Application for non-material amendment following a grant of permission relating to Planning Consent EG/38/15/PL at 97 Barnham Road Eastergate West Sussex PO22 0EQ

The application consists of;
Your application form
Drawings as approved following previous NMA;
Location & Site Layout Plans 1220/13/P/01C
Site Layout Plan and Site Section 1220/13/P/04B
Proposed Plans and Elevations 1220/13/P/06

Drawings as amended;
Location & Site Layout Plans 1220/13/P/01D
Site Layout Plan and Site Section 1220/13/P/04E
Proposed Plans and Elevations 1220/13/P/06B

Drg No: 1220/13/P/01D

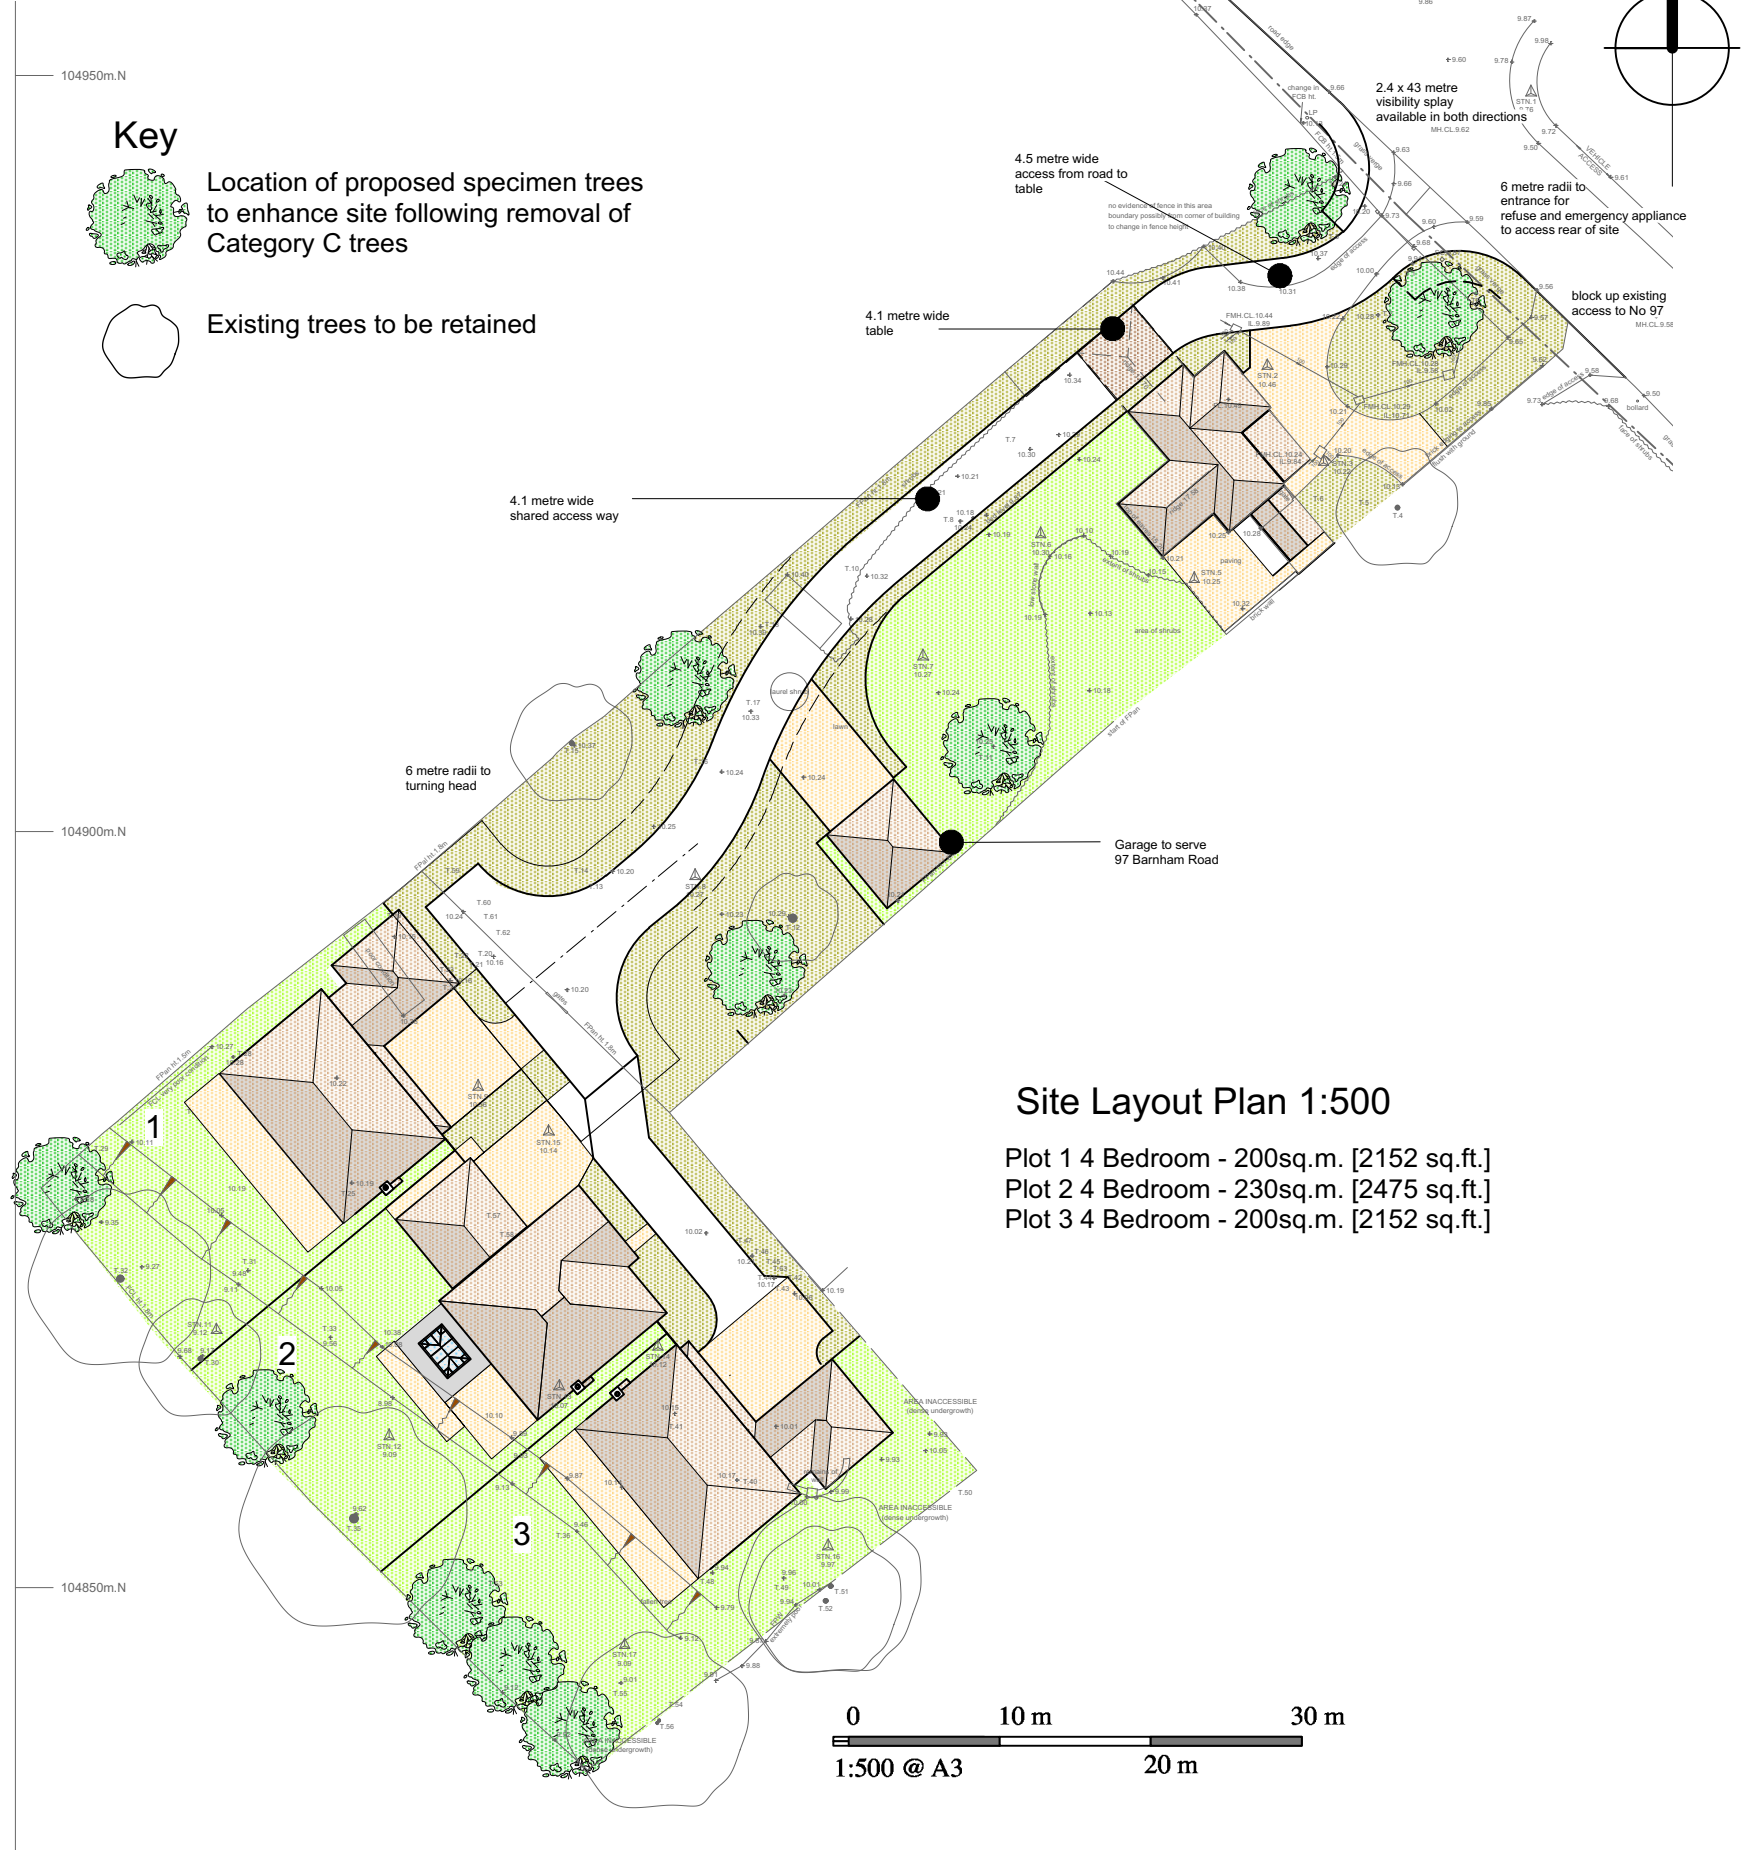
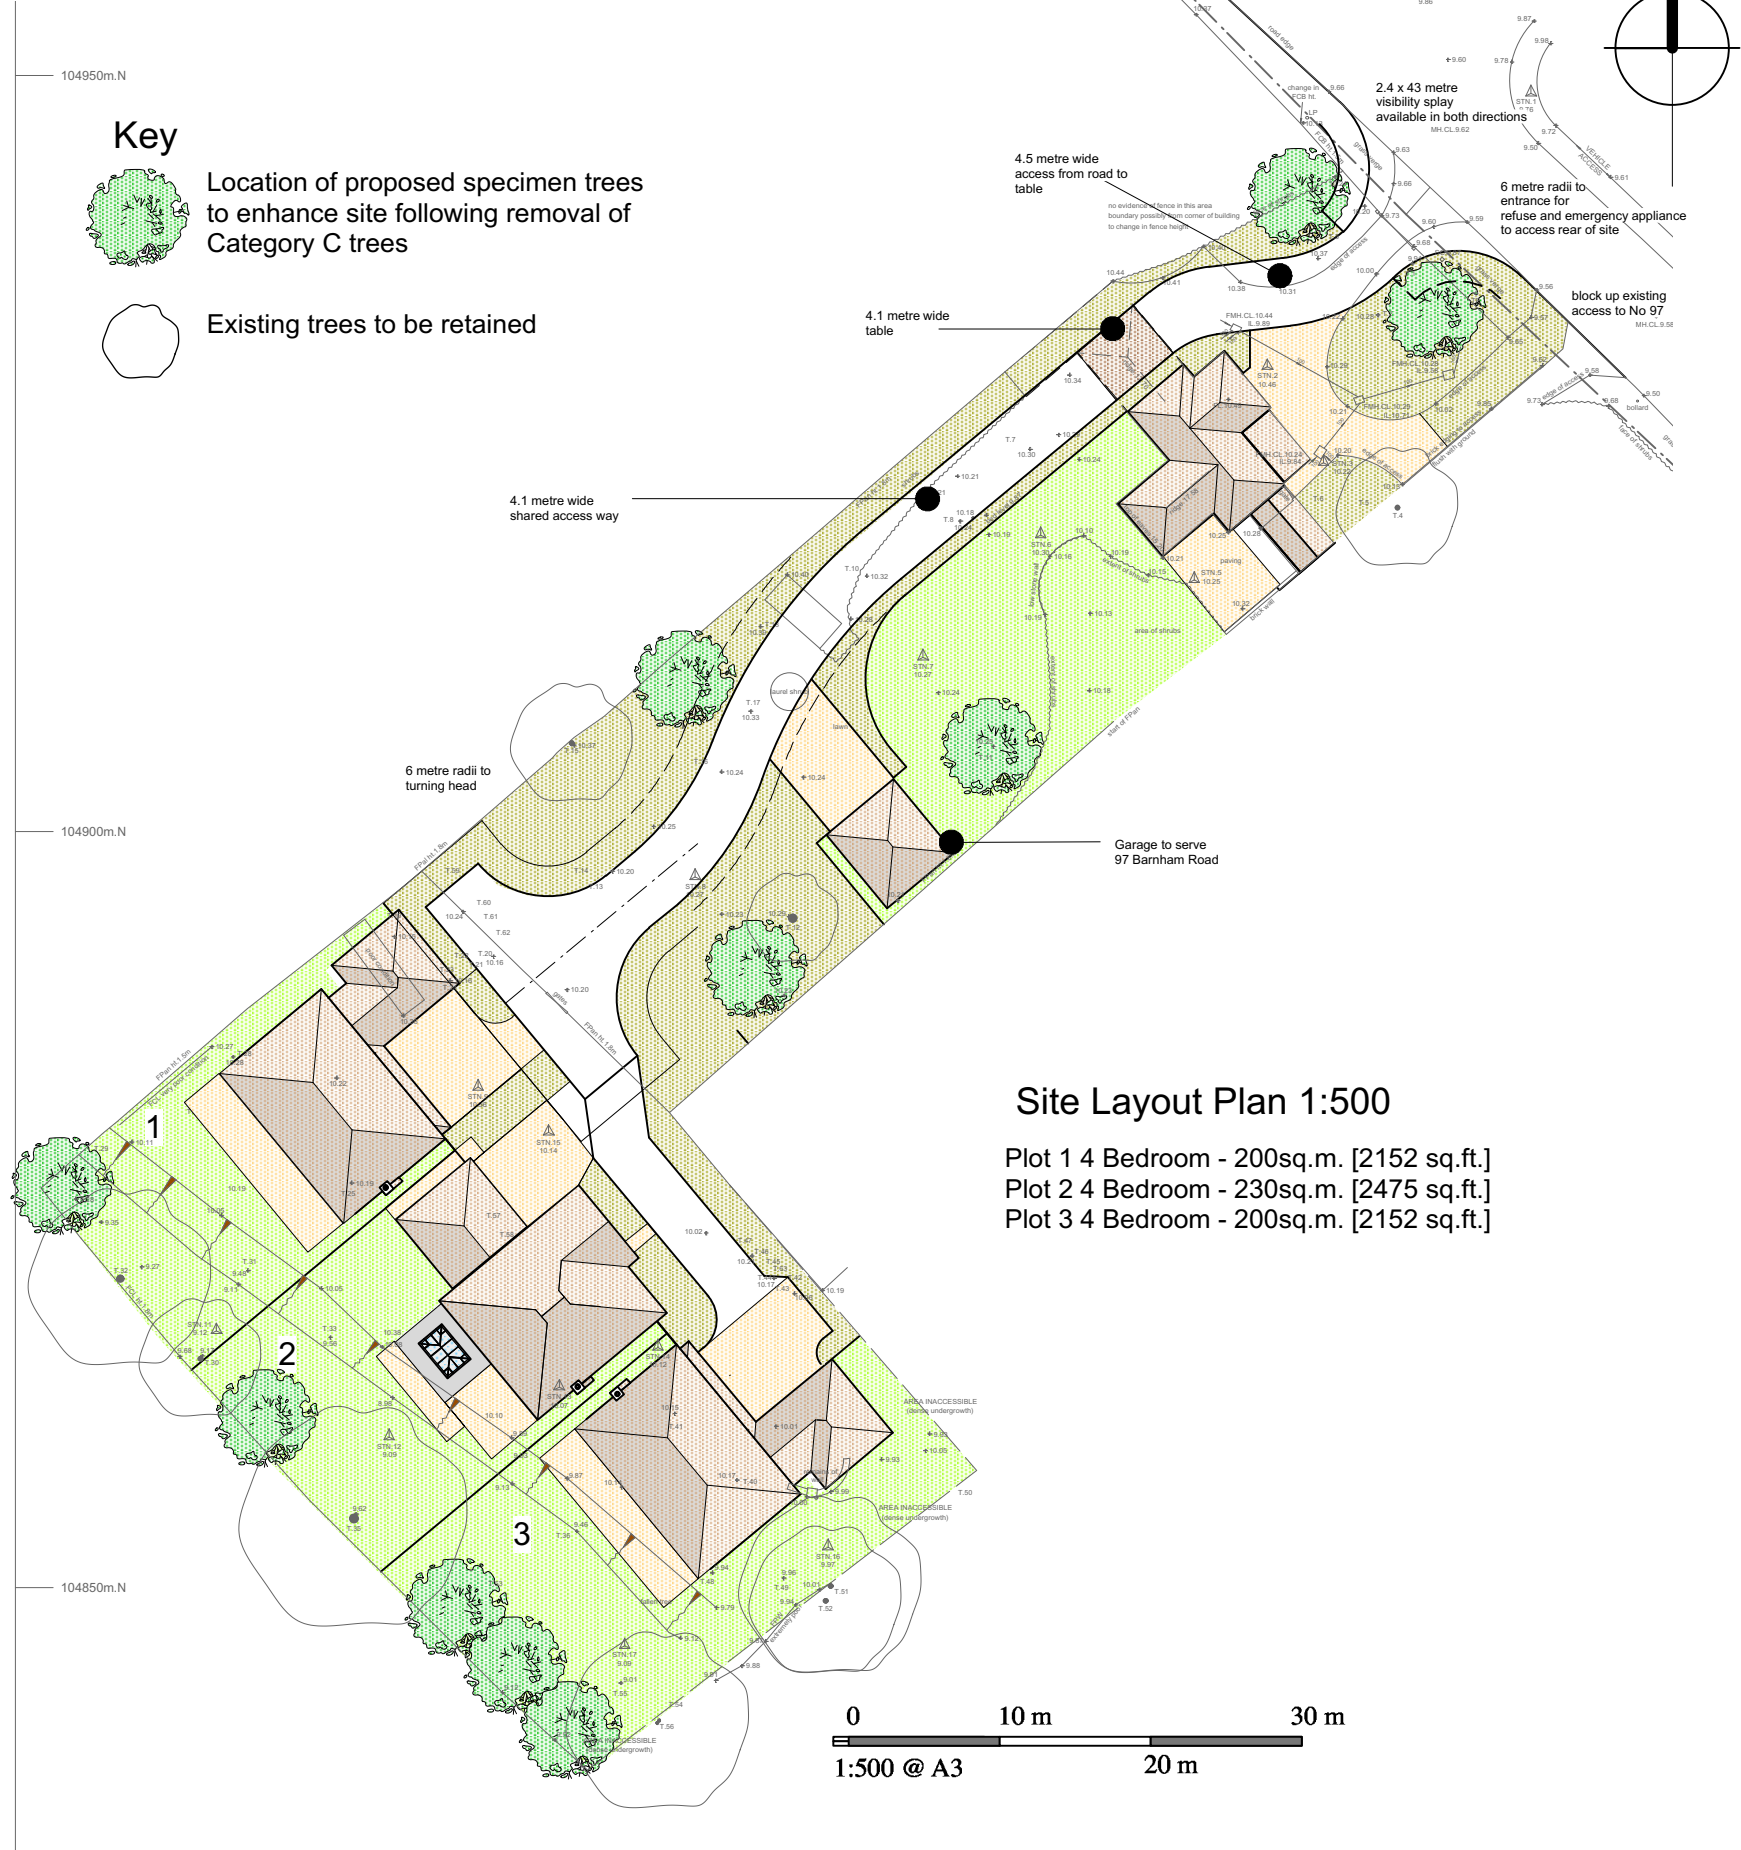
Firstly, to reduce size of single storey side extension to south east elevation to leave a separation distance of one metre from the adjoining property. Refer to drawings, 1220/13/P/01D, 1220/13/P/04E, and 1220/13/P/06B.
